From: Dunderdale, Chris <Chris.Dunderdale@lancashire.gov.uk>
Sent: 26 November 2018 14:48
To: Stephen Kilmartin
Cc: planning
Subject: RE: 3/2018/0914

Thank you for re-consulting the Lead Local Flood Authority (LLFA) on the above application. I have had a look through the information provided and I have the following observations to make:

The application is for the erection of 188 new dwellings including means of access and associated works. To include 57 affordable dwellings (29 affordable rent and 28 shared ownership).

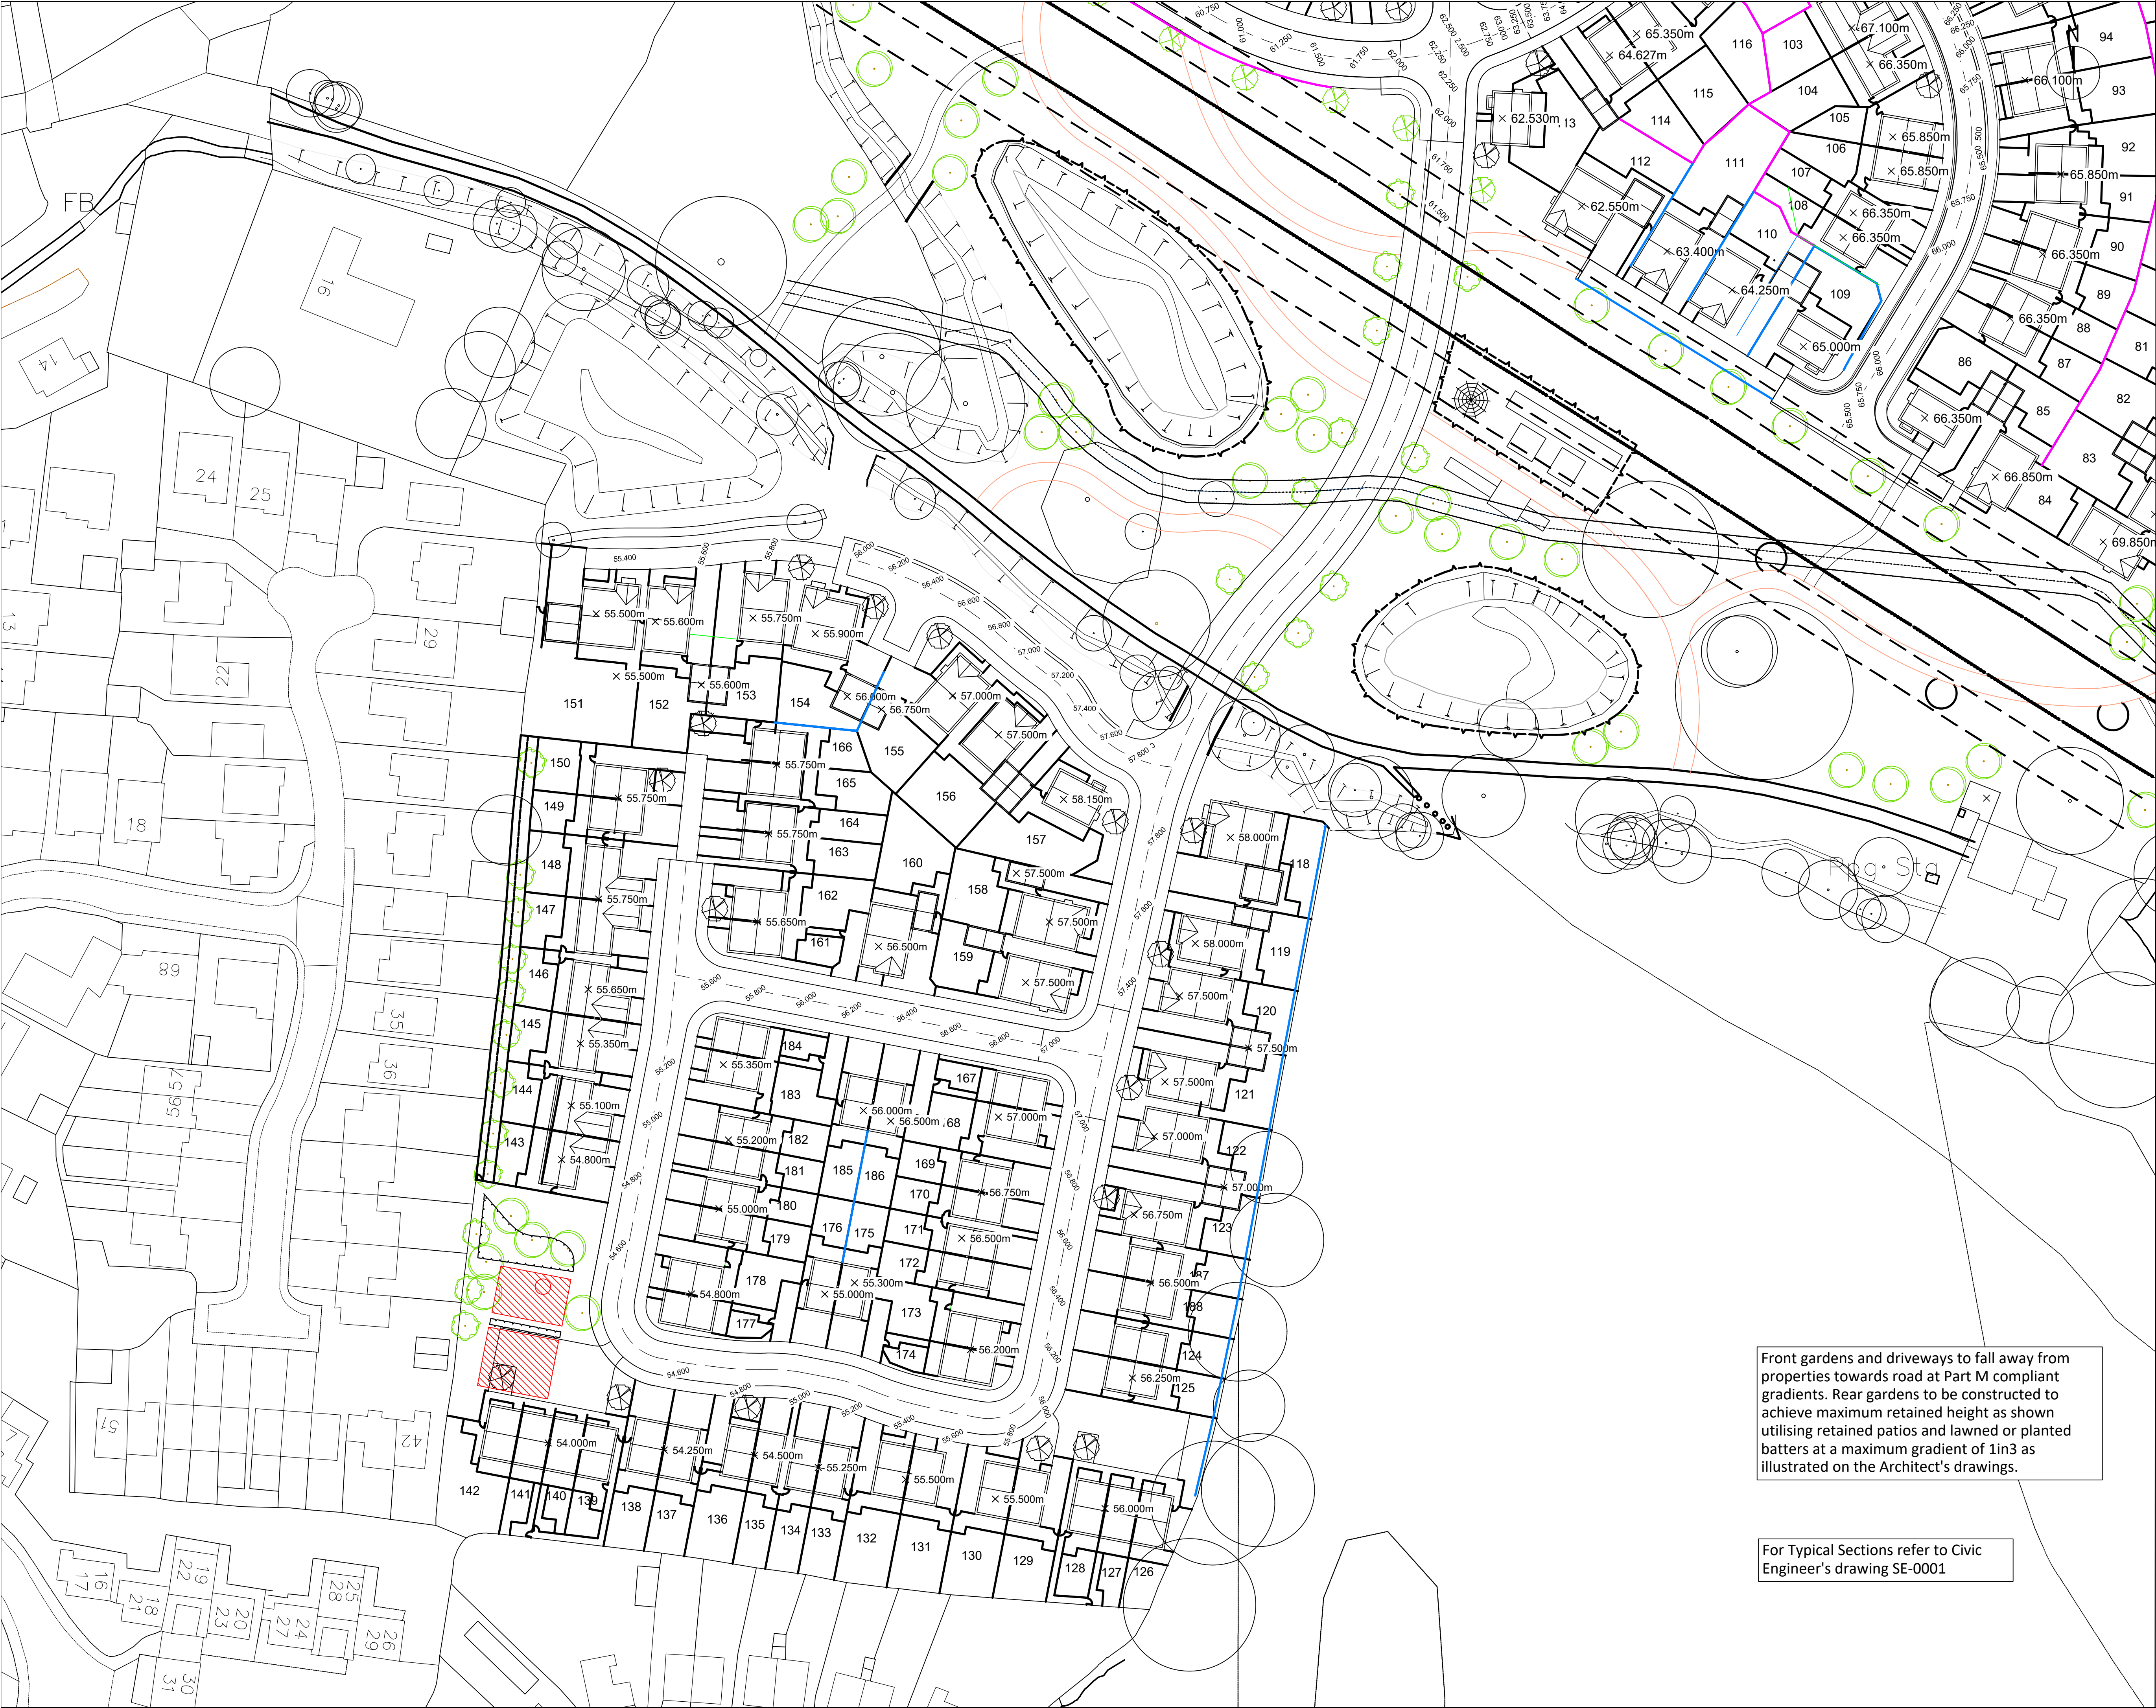
- 5) The applicant has failed to provide sufficient details relating to the intended changes in site levels across the site and the impacts that this may have on local flood risk (both on and off site). Please can you bring this to the attention of the applicant and ask for further information to be provided in this regard?
